DECISION DELEGATED TO HEAD OF PLANNING

Application No: H23-1062-24 **Applicant:** Mr D Dlugosz

Proposal: Use of site for storage of campers and caravan trailers

Location: Valencia Cranesgate North Whaplode St Catherine

SITE PLAN - EXISTING
LOCATION PLAN

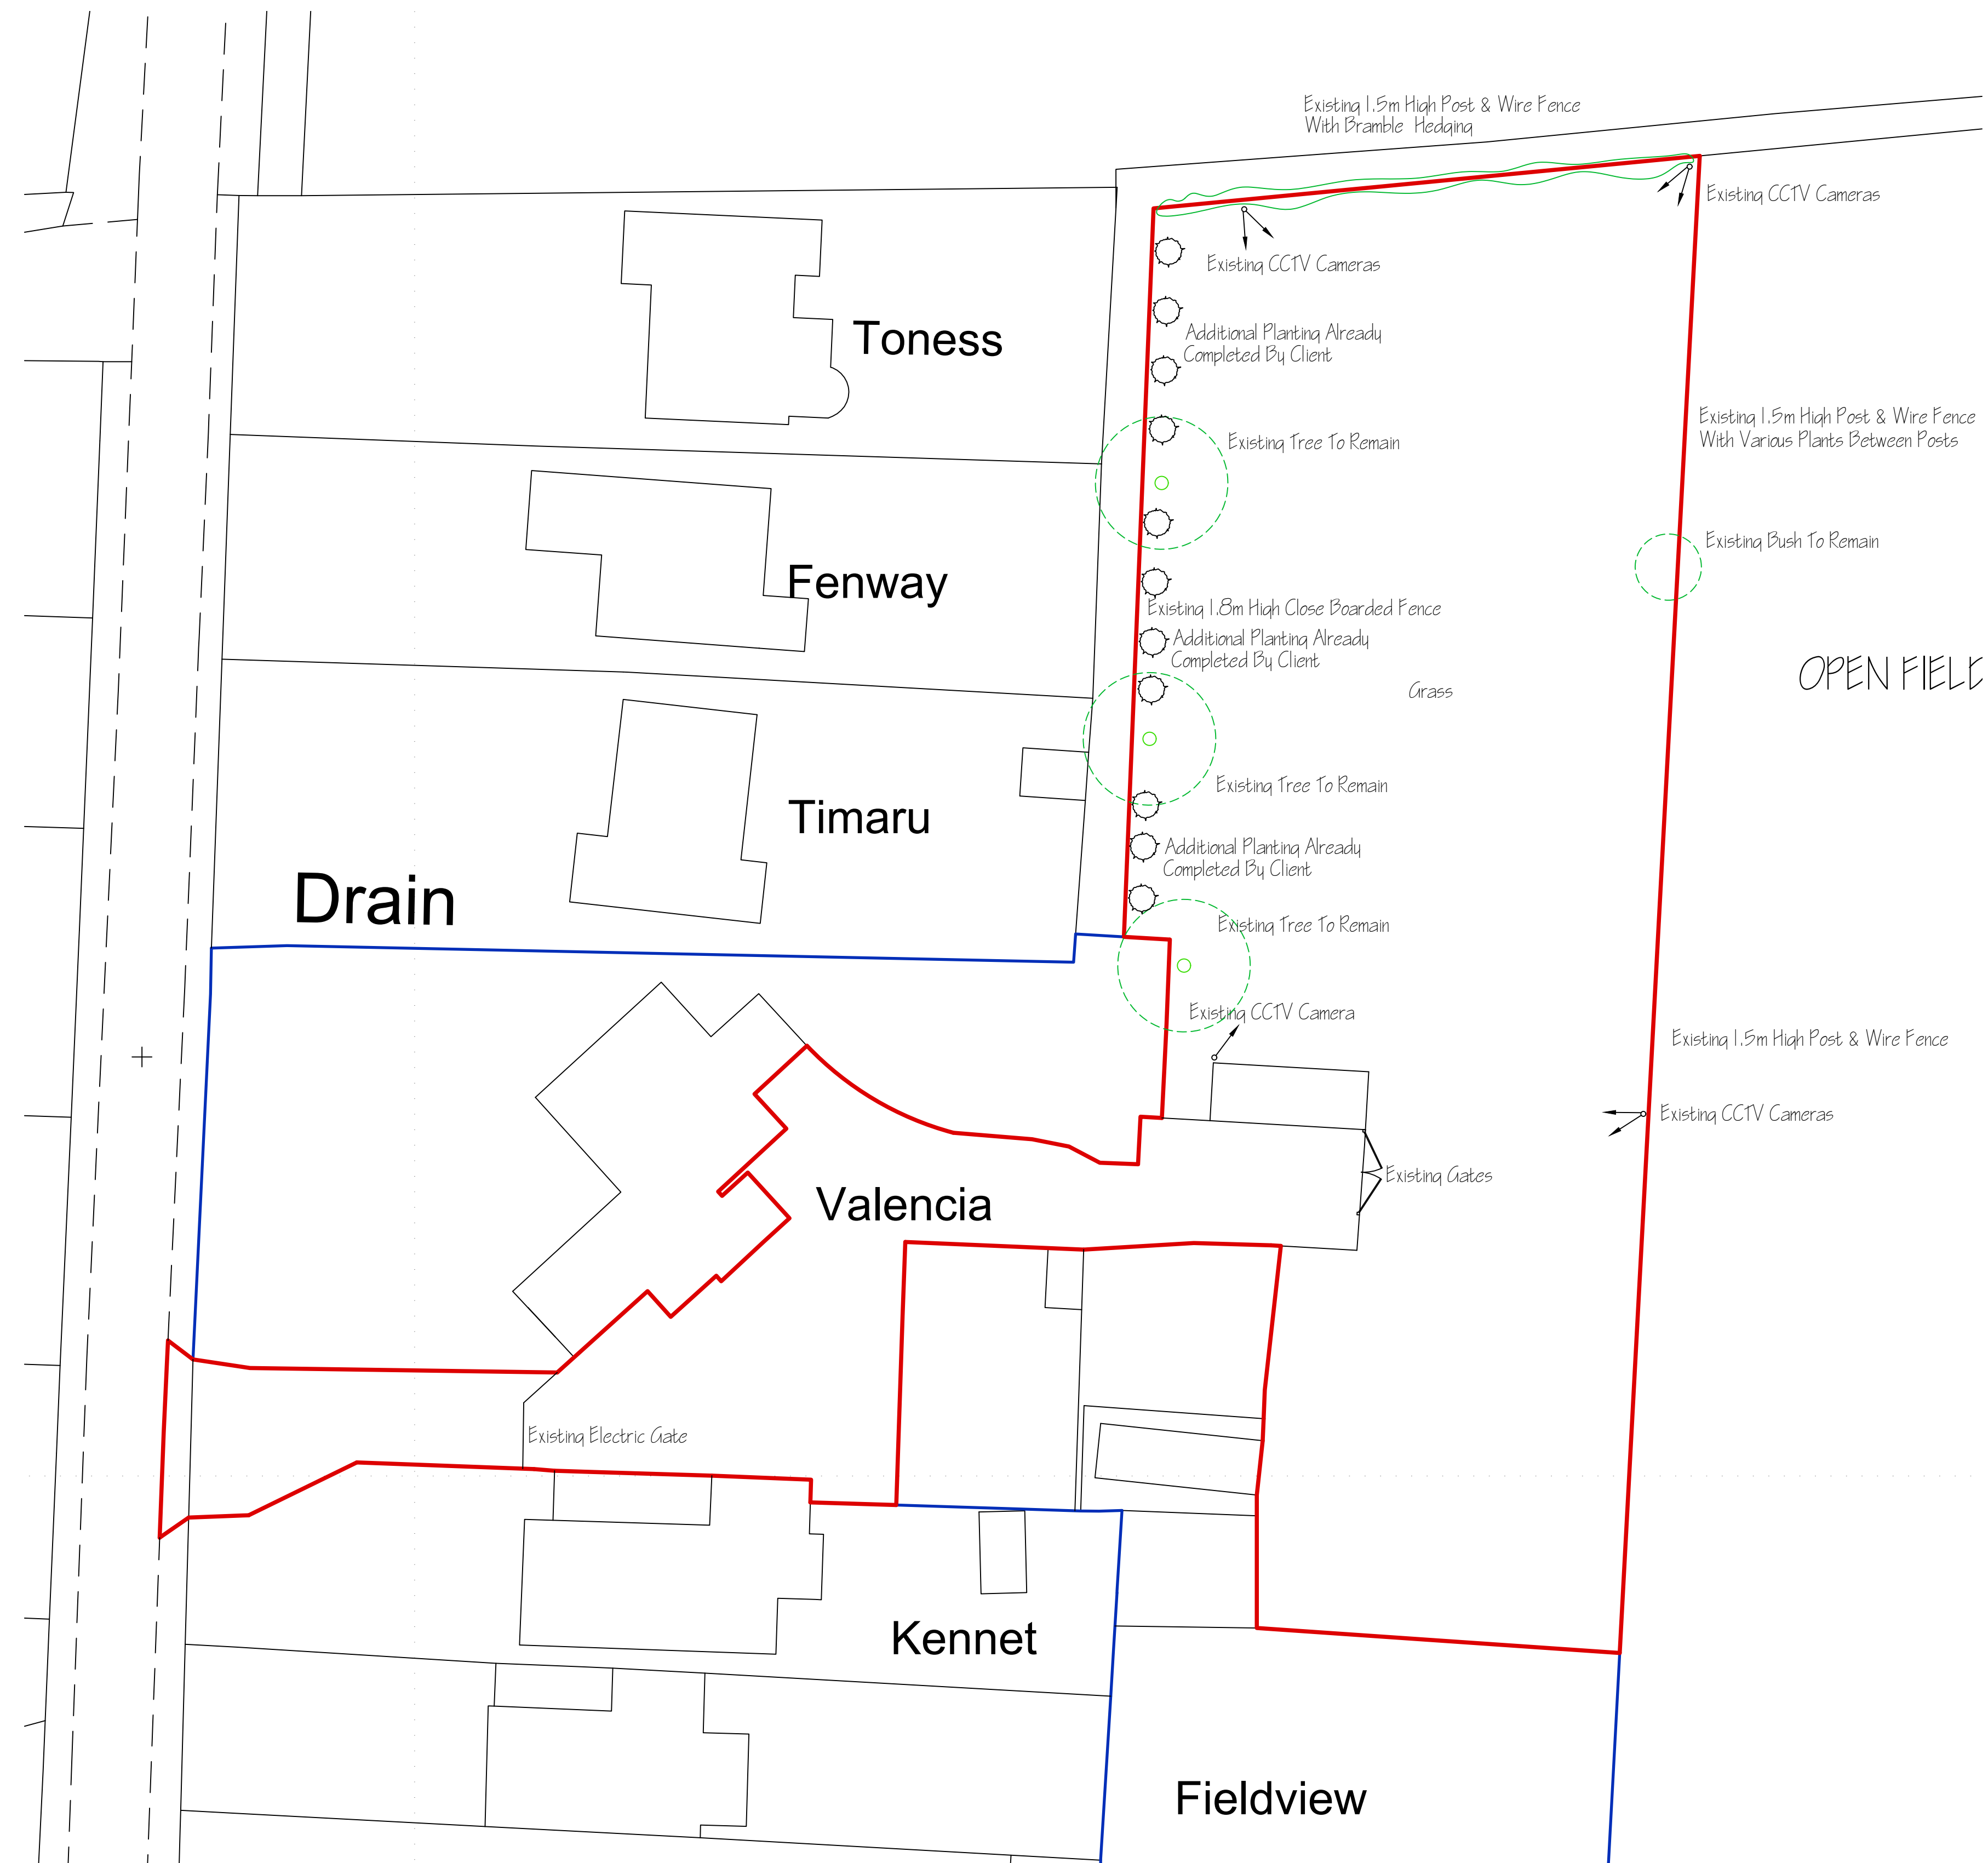
This application has been subject to amended plans, these relate to information that has arose during the application process where it is now understood that the applicant does not owned the full width of the access (as shown on the original location plan). This reduced access width has resulted in the need to demonstrate acceptable tracking patterns for accessing and egressing vehicles.

During the application process amended plans have been received which shows a much reduced assess width. This came to light through the public consultation process. Whilst a similar development has been assessed before on this site, it was assessed on the basis that the access mouth was much wider and subsequently highways did not object.

At this stage then it is clear, given the reduced access widths there are currently 3 issues, they are:
The swept path shows that vehicles will overrun the highway verge in order to be able to turn into the site

The access width includes the radius from the north whereas the swept path details vehicles entering from the south, this is misleading, the access width is therefore disputed.

They are still showing two-way traffic when this cannot be achieved - Highways had previously said that a booking in/out system will be conditioned so that two way traffic was not required.

At this stage then it is considered that insufficient information has been provided to demonstrate that a safe access/egress to the development can be achieved. The proposal is therefore contrary to SELLP Policies 2 and 3 as well as section 9 of the NPPF.
